LANDSCAPING SCHEME FOR Mr & Mrs D. SAVAGE,
ASH TREE HOUSE, BIRDS DRIVE, GOSBERTON
REF: PSU/JK/H17/0858/94

Application No: H17/0858/94

Description of Original Development: Details of landscaping
(Condition 2 of
application H17/0858/94)

3B

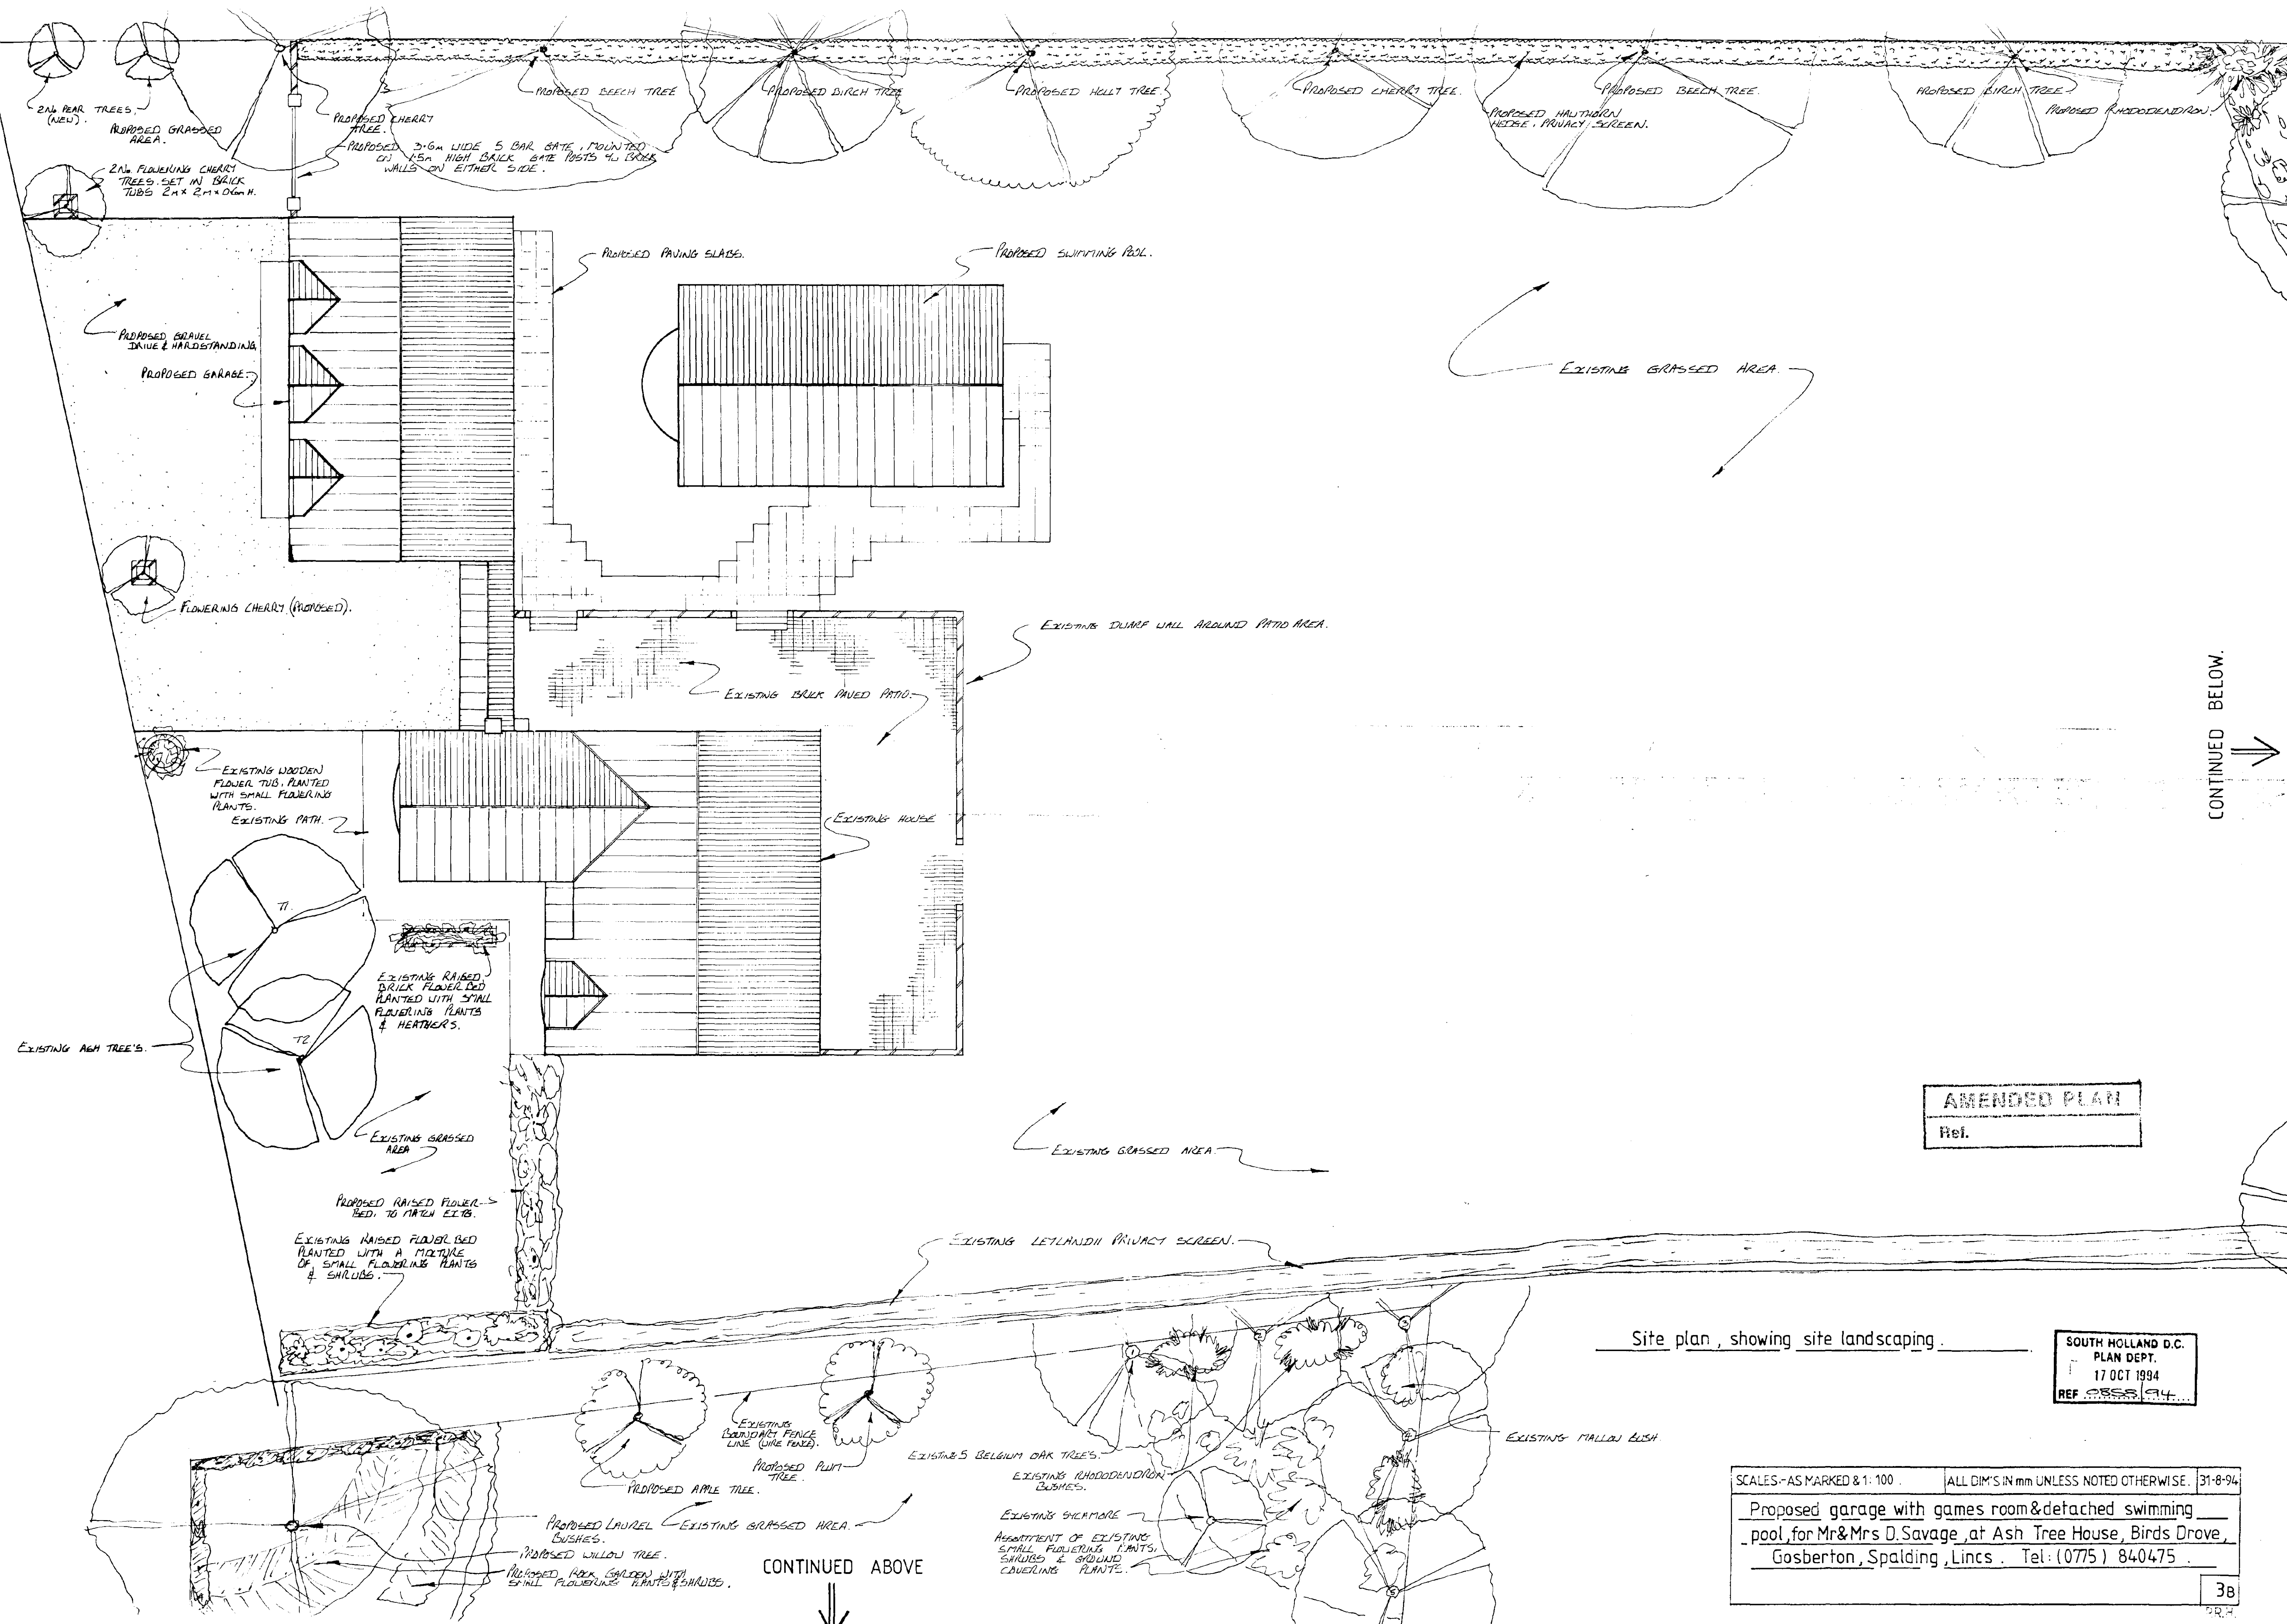
1. Mr & Mrs SAVAGE ARE WILLING TO PLANT
THE NUMBER, VARIETY & SPECIES OF
TREE'S & HEDGES ALONG THE EASTERN
SITE BOUNDARY WHICH YOU REQUIRE.
2. AS AGREED, THE HEDGE WILL BE A
HAUTHORN AND WILL RUN FROM THE
CHERRY TREE AT THE FRONT BOUNDARY
ALL THE WAY ALONG TO THE REAR
BOUNDARY.
3. ALSO AS AGREED, TREE'S WILL BE A
MIXTURE OF BIRCH, HOLLY, CHERRY AND
BEECH. THESE WILL BE PLANTED TO
SCREEN THE PROPOSED STRUCTURES, BUT
WILL ALSO BE INTERSPERSED ALONG THE
REST OF THE LENGTH OF THE EASTERN
BOUNDARY.
4. HAVING SPOKE TO Mr ROBBY STAYTON IN
BUILDING CONTROL, I CAN CONFIRM THAT
THE AFFOREMENTIONED SPECIES OF TREE'S WILL

NOT HAVE A SERIOUS DETREMENTAL EFFECT ON THE FOUNDATION DESIGN. AS MOST SPECIES HAVE A LOW OR MODERATE WATER DEMAND THE FOUNDATION DEPTH ALONG THE EAST ELEVATION OF THE GARAGE WOULD ONLY NEED TO BE INCREASED FROM 760mm ϕ TO 1.000m ϕ .

IN ACCORDANCE WITH THE COUNCIL'S
INSTRUCTIONS, THE LANDSCAPING TO
THE EASTERN BOUNDARY HAS
BEEN CHANGED TO A CONTINUOUS
HAUTHORN HEDGE WITH BEECH,
BIRCH, CHERRY & HOLLY TREE'S.

5. A FURTHER 4 COPIES OF REVISED DRAWING 3B ARE ENCLOSED, TOGETHER WITH PLANNING AMENDMENT FORMS AS REQUESTED.
